RE: DFT Review Comments for Route 66 Flats (7600 Central Ave SW)
Project Number: PR-2024-009904

On behalf of High Desert Housing and BlueLine Development, thank you for your Site Plan review of the new affordable housing community located at 7600 Central Avenue SW.

Please see the attached comment responses to Plan Review #1, if there are any questions pertaining to the responses, please let us know- Thank you Ed Parcell.

**A6 TRASH ENCLOSURE ENLARGED PLAN**  
 1/4" = 1'-0"

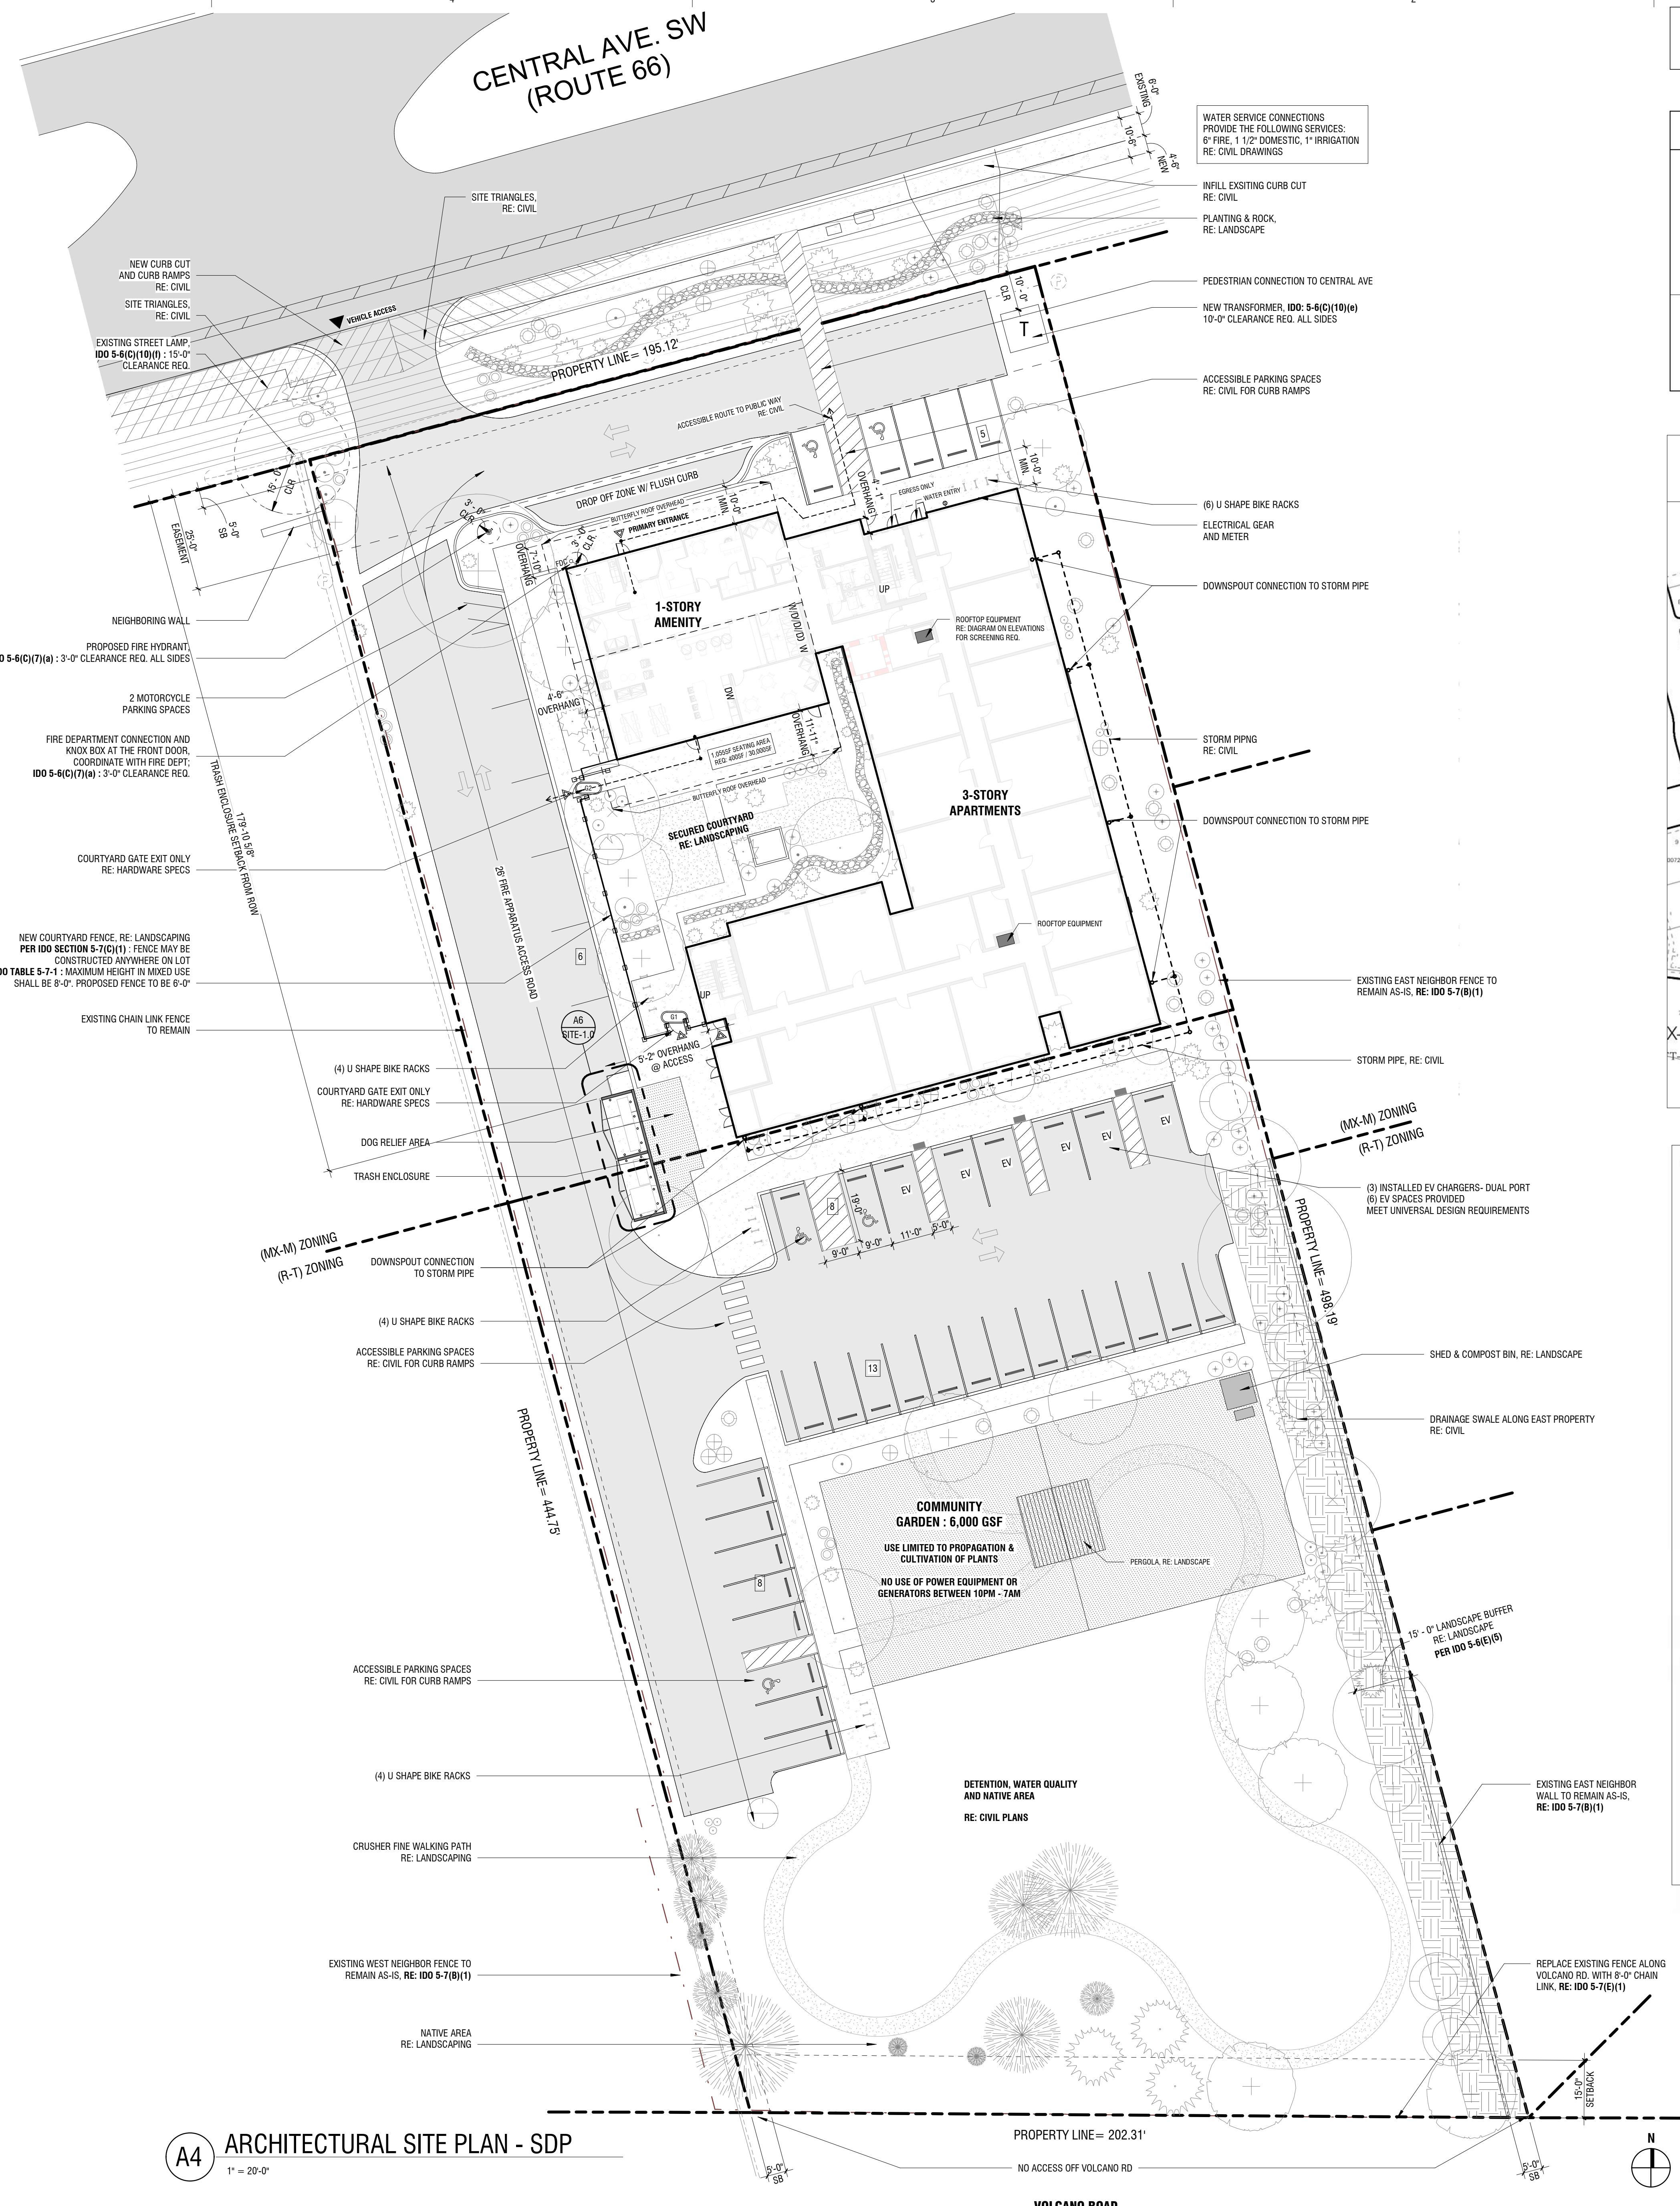
Move the trash enclosure so it is only in one of the zones ***(SW Response): since this is one zone lot the trash enclosure will be left as design, any changes to the location would impact the required fire lane on the south side of the building.***

**A** OVERALL LANDSCAPE SITE PLAN & SHEET LAYOUT  
SCALE: 1" = 20'

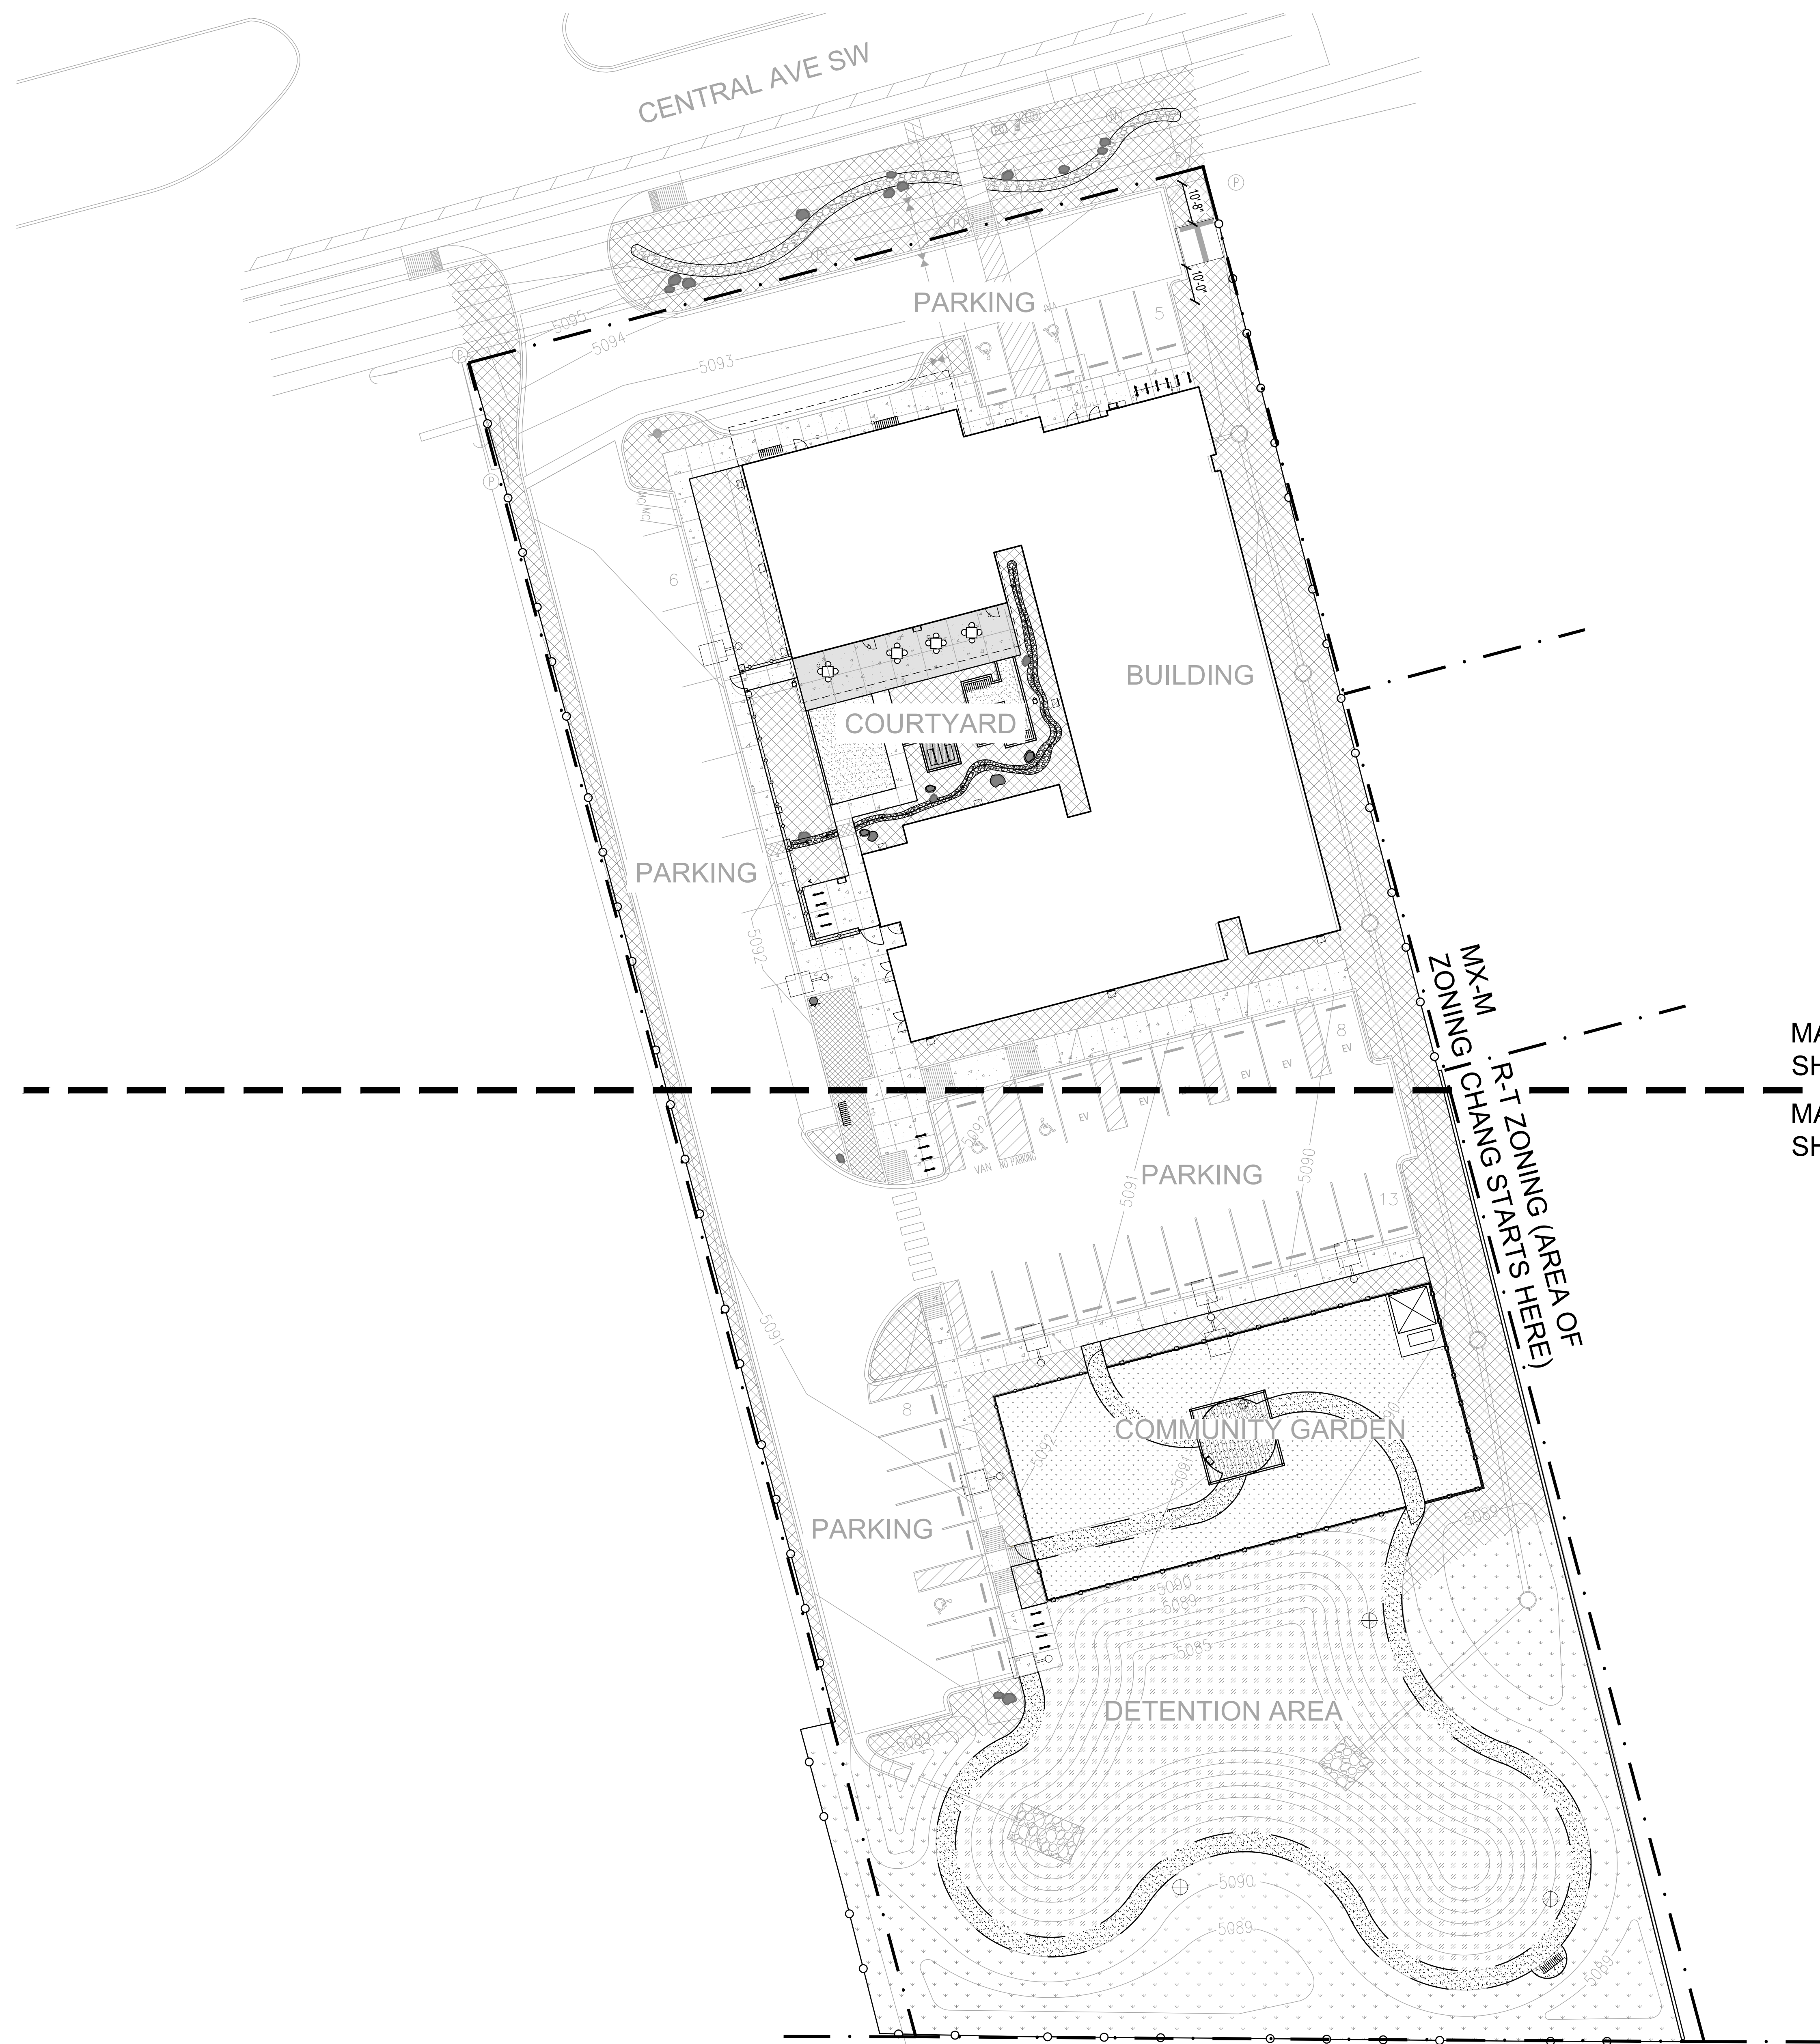
Minimum Landscape Area, a minimum of 15 percent of the net lot area of each development shall contain landscaping. Minimum required landscape area is 11,682 sq. ft. and the provided landscape area is 13,810 sq. ft.- **(Flow response) Landscaping requirements are met and are shown in the 'Landscape Requirements Chart' on sheet LS100**

The mature realistic spread of trees and shrubs will be used to calculate required vegetative coverage as follows. (SEE CALCS IN COMMENTS) **(Flow response): Landscaping requirements are met and are shown in the 'Landscape Requirements Chart' on sheet LS100**

Please show proper calculations to indicate the area of each of the items mentioned above separate from the landscape area. **(Flow response): Calculations provided in ‘Multi-Family Dwelling Requirements’ chart on sheet LS100**

The use of gravel or crusher fines as ground cover is limited to a maximum of 75 percent of any landscaped area. **(Flow response): Calculation provided in ‘Multi-Family Dwelling Requirements’ on sheet LS100**

**D NORTHERN COURTYARD GATE**  
SCALE: 1/2"=1'-0"

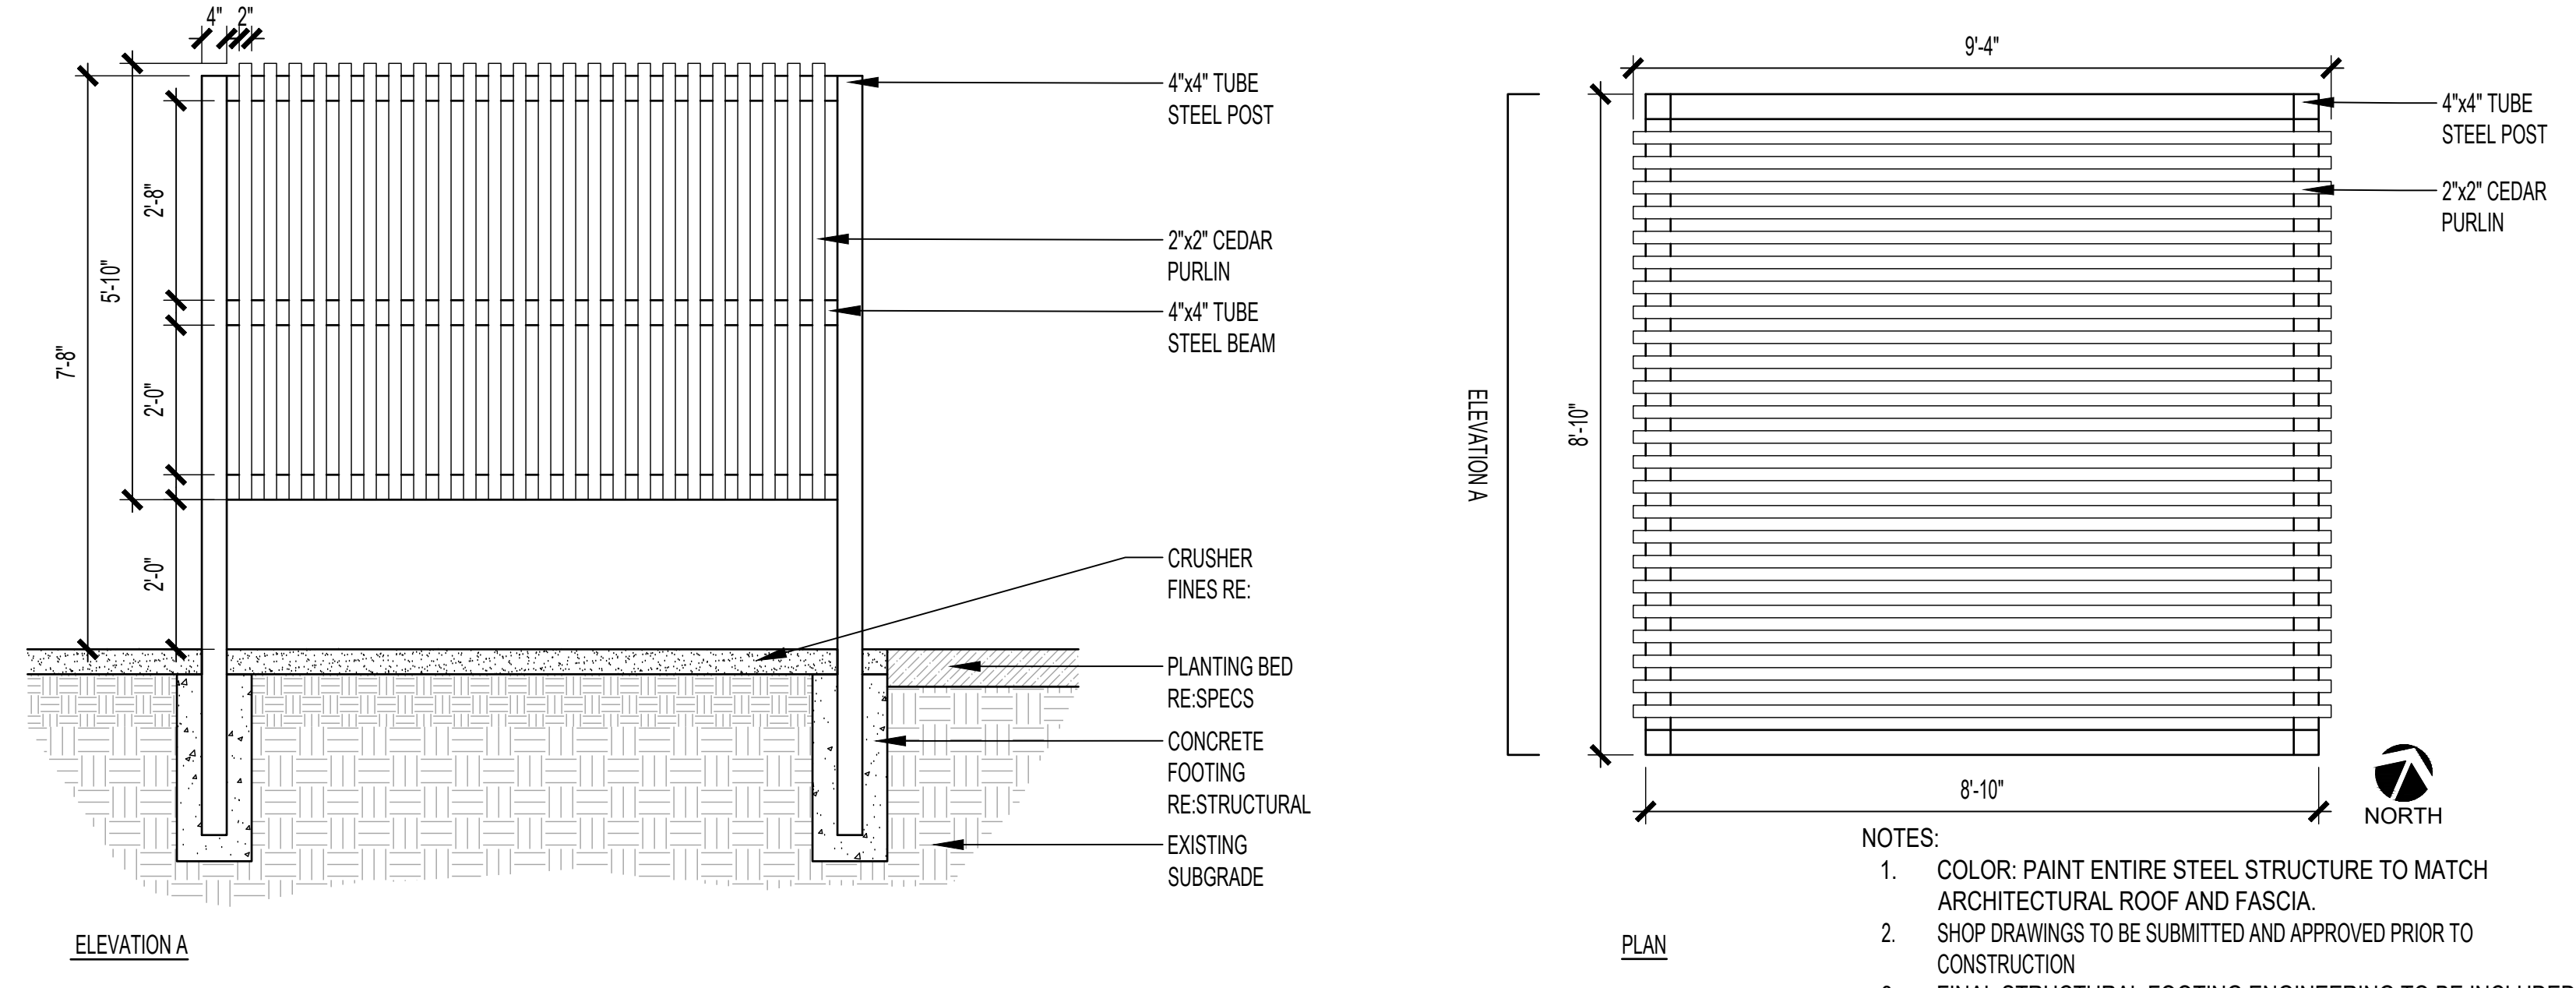
Accessory structures such as hoop houses, shade structures, and storage sheds are allowed, but no such structure shall be more than 8 feet in height- - **(Flow response): Community garden shade structure revised to meet 8’ maximum height requirement**
